**KIRKLEES METROPOLITAN COUNCIL  
INVESTMENT & REGENERATION SERVICE**

**DELEGATED DECISION TO DETERMINE PLANNING APPLICATIONS**

Reference No:	<b>2024/62/92207/W</b>
Site Address:	53, Wakefield Road, Moldgreen, Huddersfield, HD5 9AB
Description:	Erection of rear three storey house of multiple occupation
Recommending Officer:	Katie Chew

**DECISION – Refused**

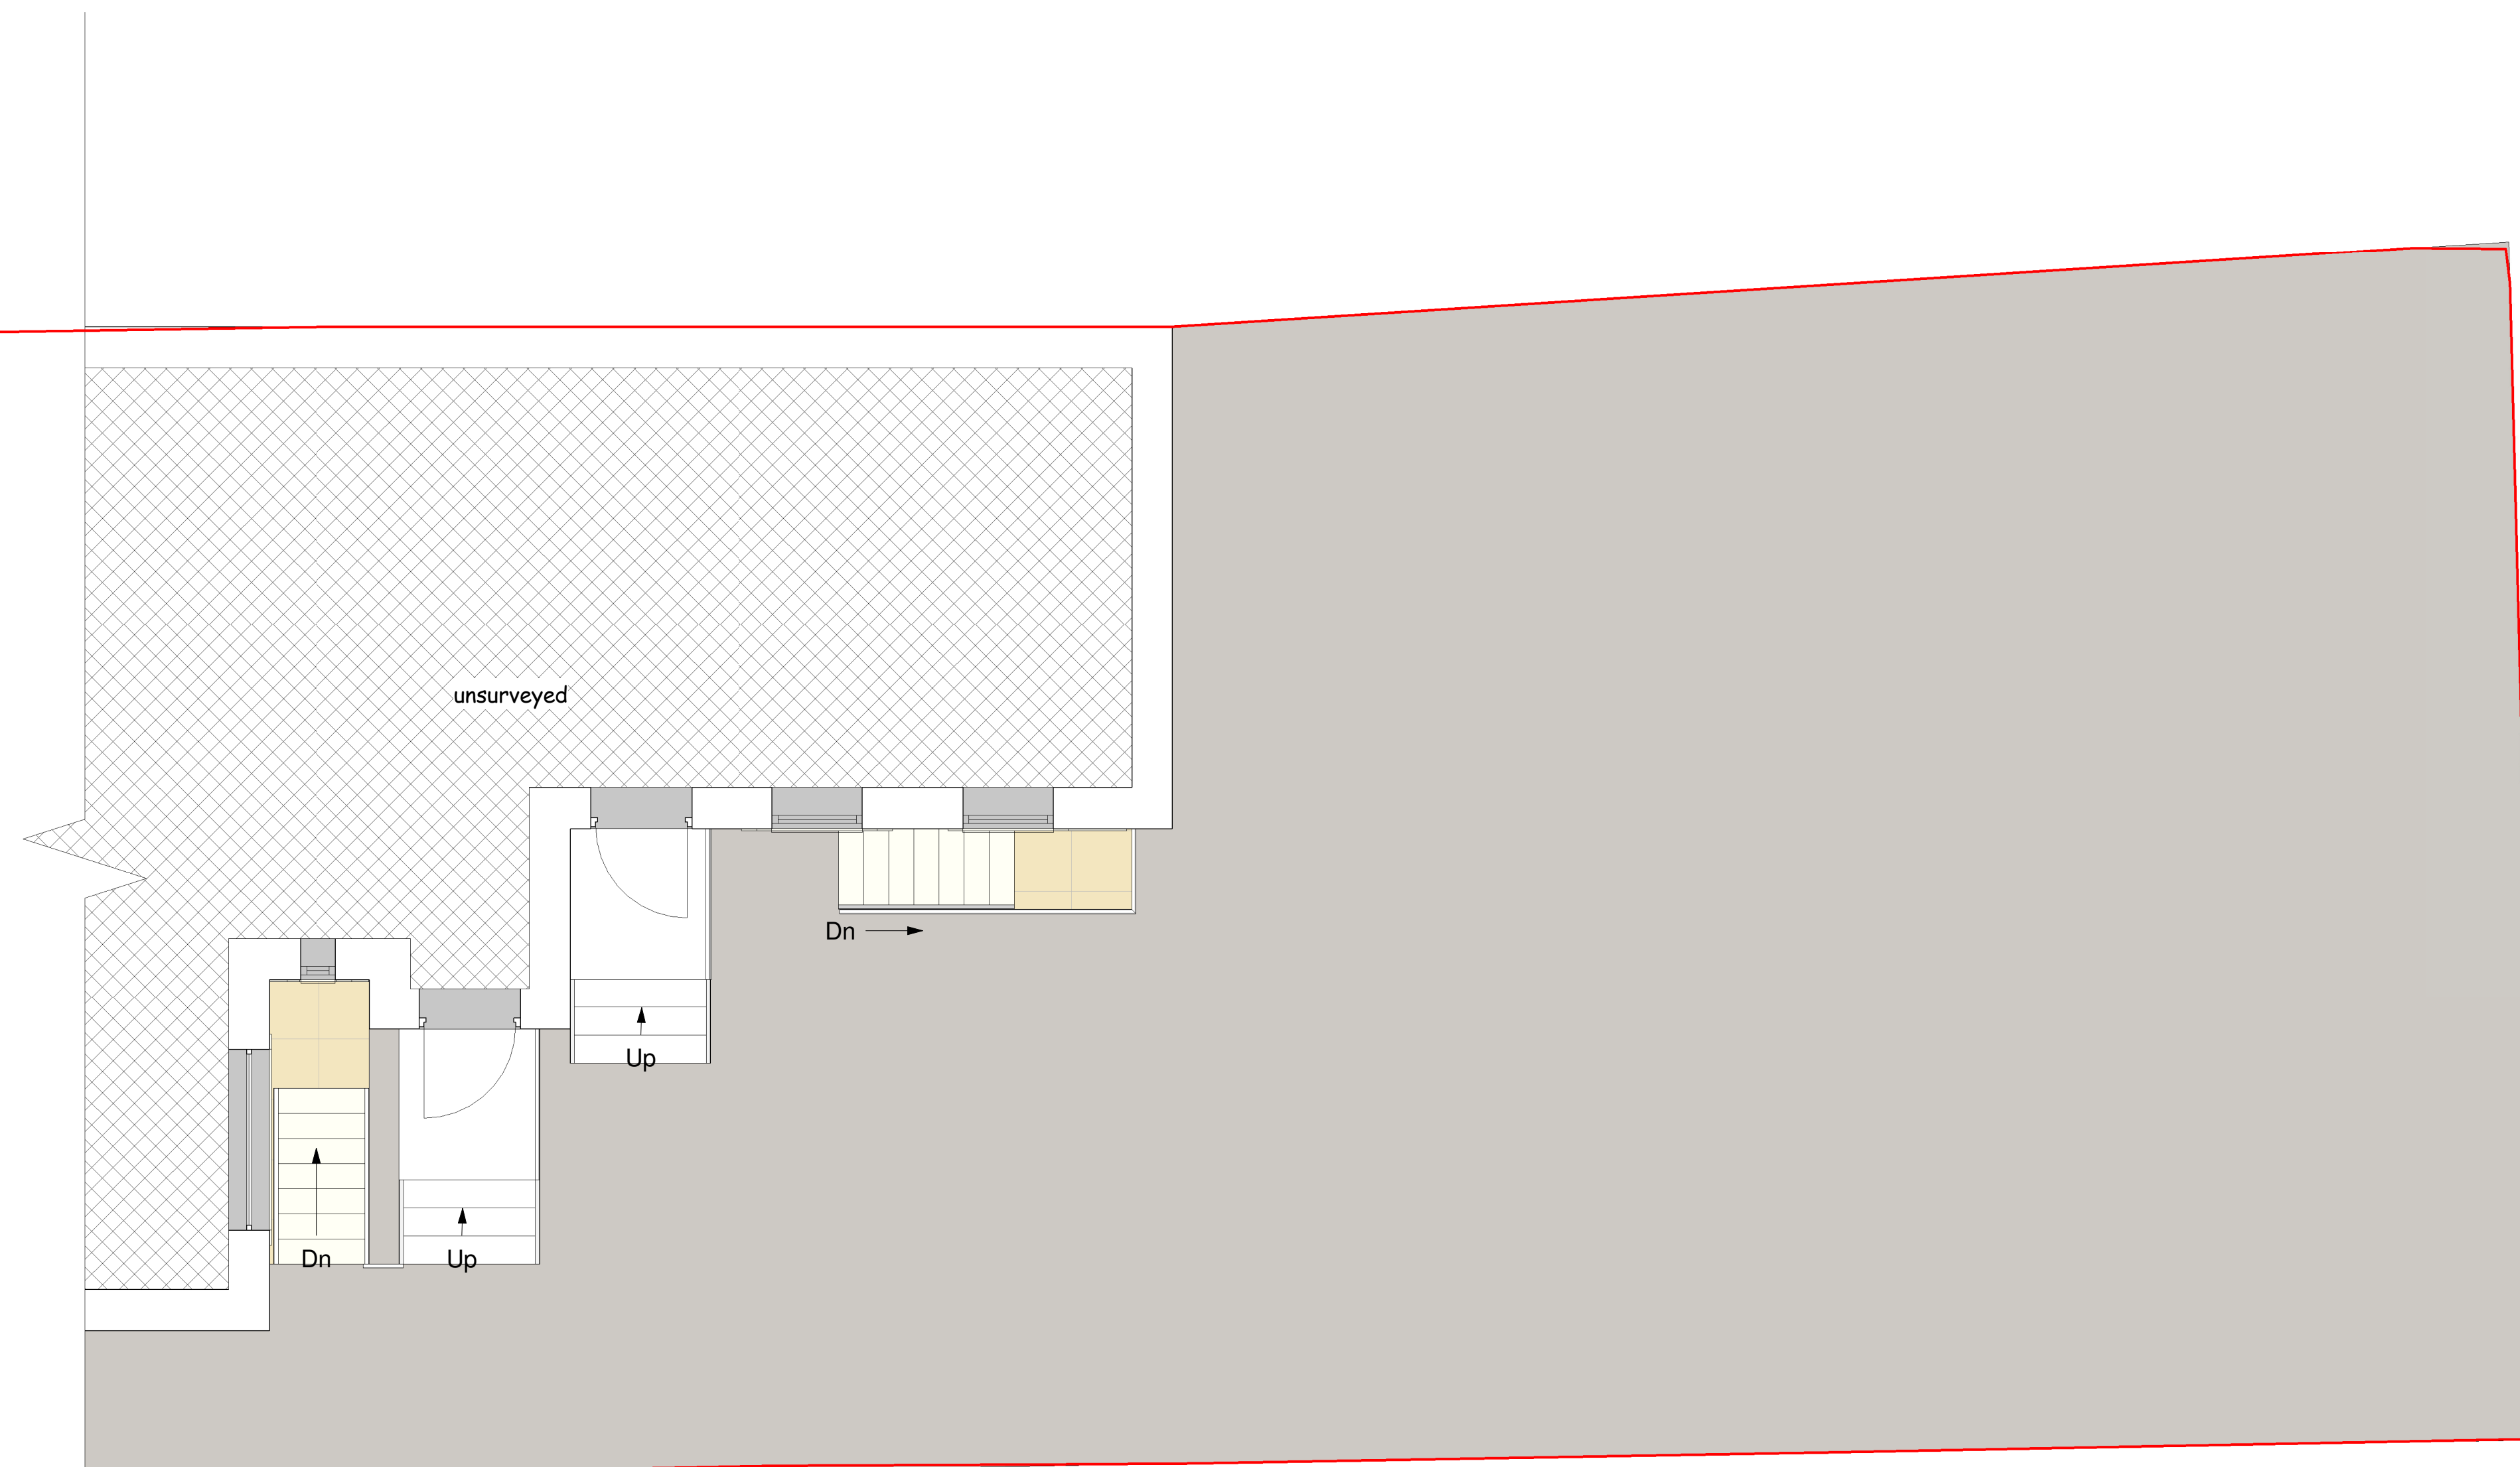
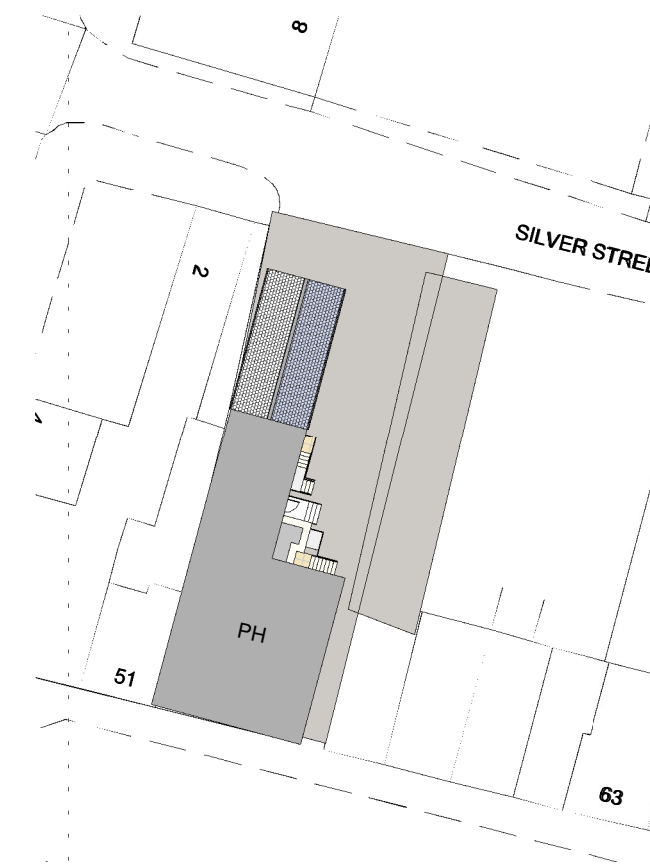
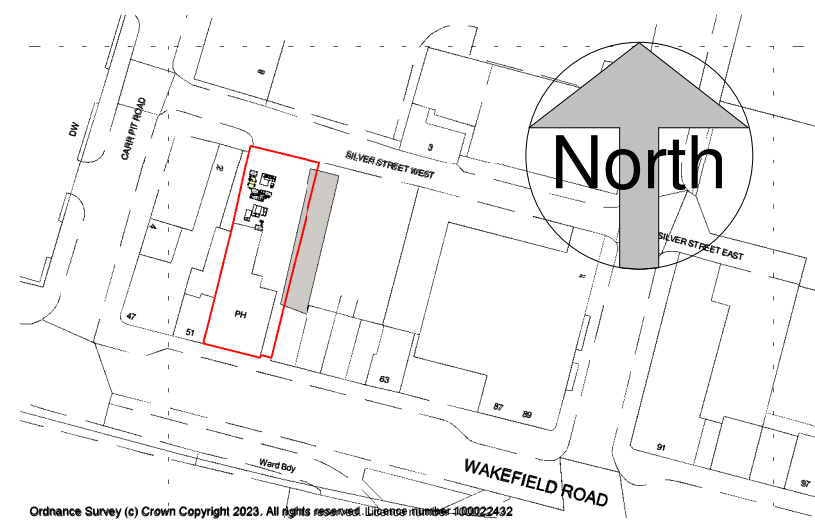
**Officer note:** Officers also note that drawing no. 2318-02 Rev A, shows the following:

- a CGI image of a 'view showing new cellar windows',
- a front elevation showing the installation of 1 new cellar window and light well, and
- an increase in the size of an existing cellar window and excavation works.

However, no details have been provided in respect of the proposed cellar within the submitted application forms, or Design & Access Statement therefore it is considered that this is an error and would need to be removed from the submitted plans. Officers have not sought this amendment given the conclusions drawn within the visual and residential amenity sections of this report.

Rear Elevation
1 : 50

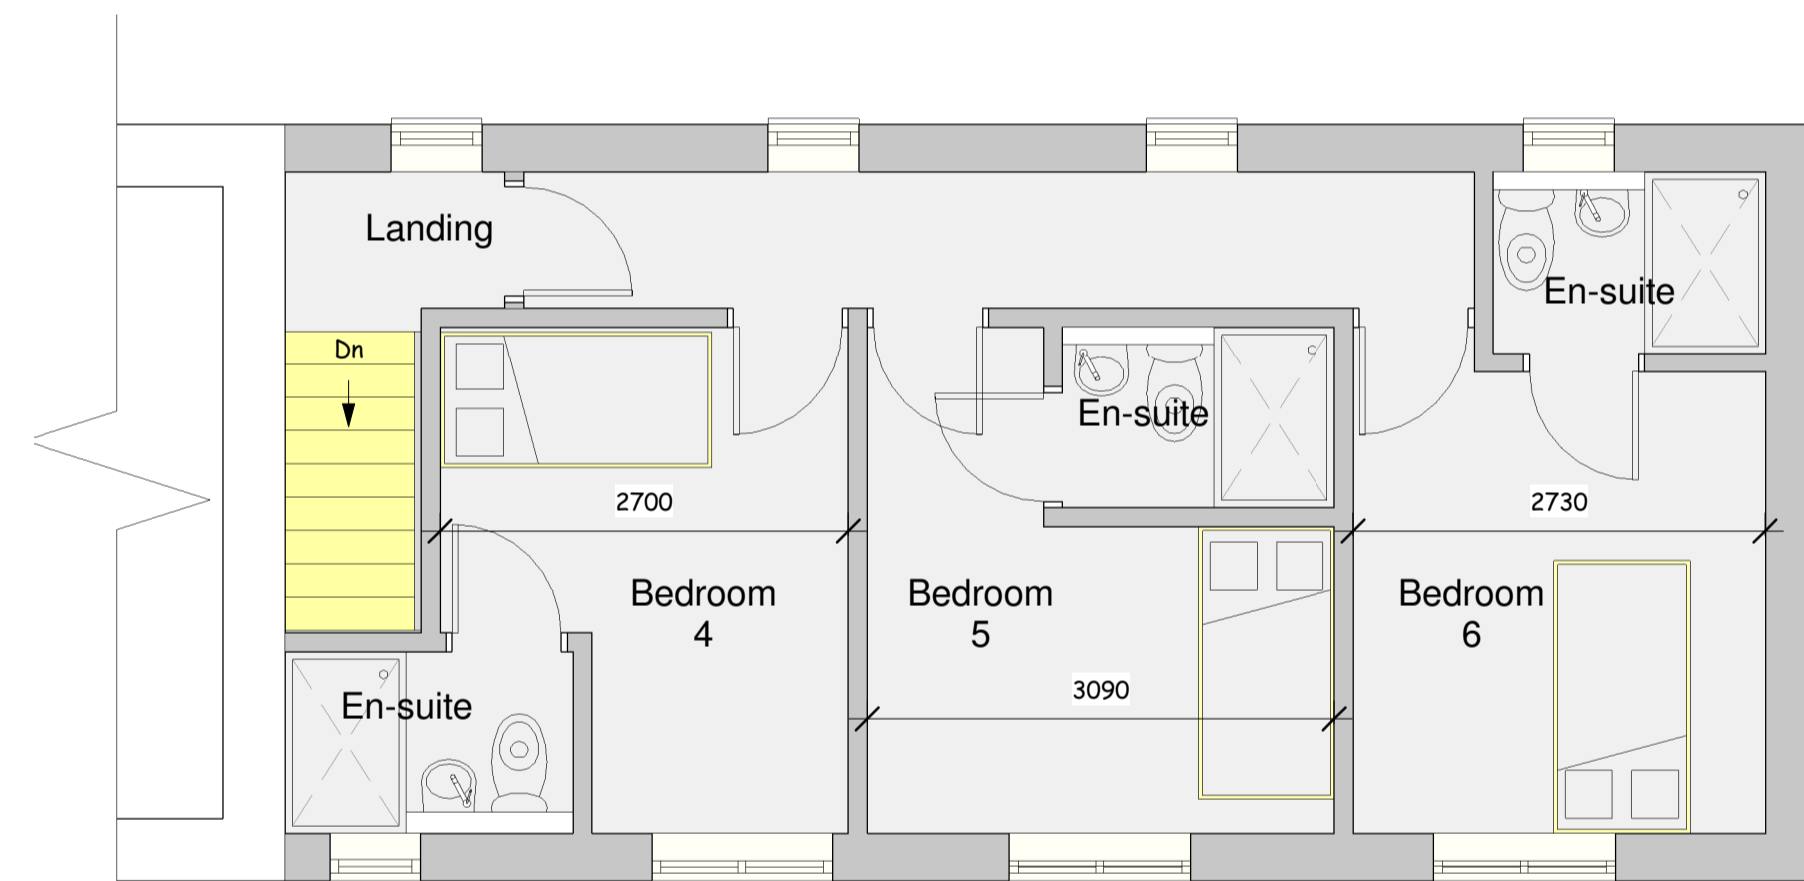
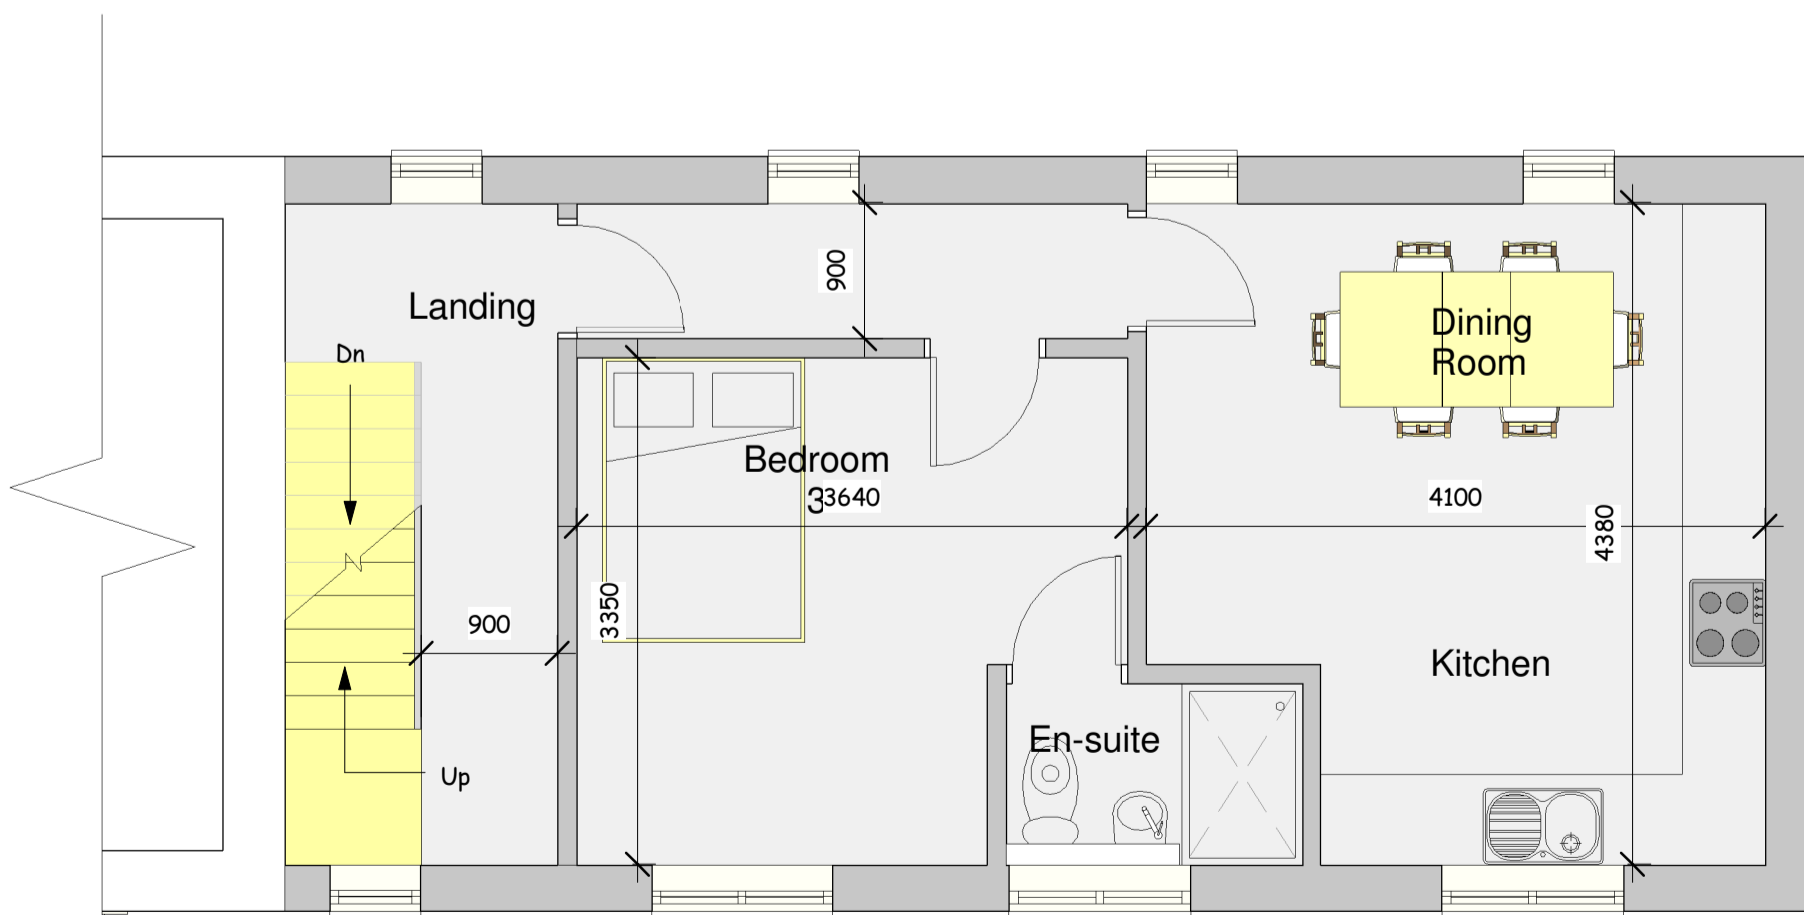
Following the previous refusal (application 2023/92216), the applicant has sought to remove the pitched roof design and replace it with a flat roof. This design would reflect the roof found within part of no. 53 Wakefield Road and therefore is deemed to be acceptable. However, in terms of the height of the building, which is to be three-storeys, this is not considered to be acceptable and would appear overly dominant and out of character in this location, as previously outlined within refused application 2023/92216. Officers would wish to see a two-storey building which either matches the height of the adjacent flats or is stepped slightly below this structure. The proposals as submitted are therefore not considered to accord with Principle 15 of the above SPD.

Moving on to windows and doors, these are considered to be of a simple and traditional appearance, equally spaced out throughout the building. However, Officers do note that due to the three-storey height of the dwelling, windows do not align with the windows in the adjacent block of flats. Should the applicant amend the proposals in line with Officers comments above (in regard to the height of the building), it would be expected that the windows be reorientated to run in line with the adjacent property, in the interests of visual amenity.

All bedroom and other primary habitable room windows would face east. The distance from the windows to the boundary with adjacent land would be approximately 6m. They would not directly face the windows of any other residential properties at close quarters – the closest possible overlooking distance between windows, even if the part of the space above no. 55 was in residential use, is 15m, and this would be at a steep angle. The distance to

the boundary however falls significantly short of the 10.5m that is recommended. Development on this site, with east-facing windows, would also undermine the development potential of the adjacent plot, since any new development over a single storey would have to be set away from the boundary so as to allow the 12m stand-off distance between a habitable room window and blank wall to be maintained. However, since the adjacent plot is without designation and is unlikely to have any development potential as any new build would displace existing parking, it is considered that this factor would be unreasonable to substantiate as a reason for refusal.

The Nationally Described Space Standards (NDSS) recommend that overall floorspace should normally be at least 129sqm for a three-storey dwelling with 6 bedrooms. Gross internal floorspace in this instance would be approximately 125sqm. Officers do acknowledge that bedrooms 4, 5 and 6 would only be suitable for 1 person given their size. Rooms of this size would not meet the minimum requirements of the NDSS for 2-person occupancy, however this is by a marginal shortfall.

Officers acknowledged that all habitable rooms would have access to at least 1 window, and that the first and second-floor windows would have an open outlook. Outlook and receipt of light for the two ground floor bedrooms numbers 1 and 2 would however be very poor as they would face a high stone boundary wall.
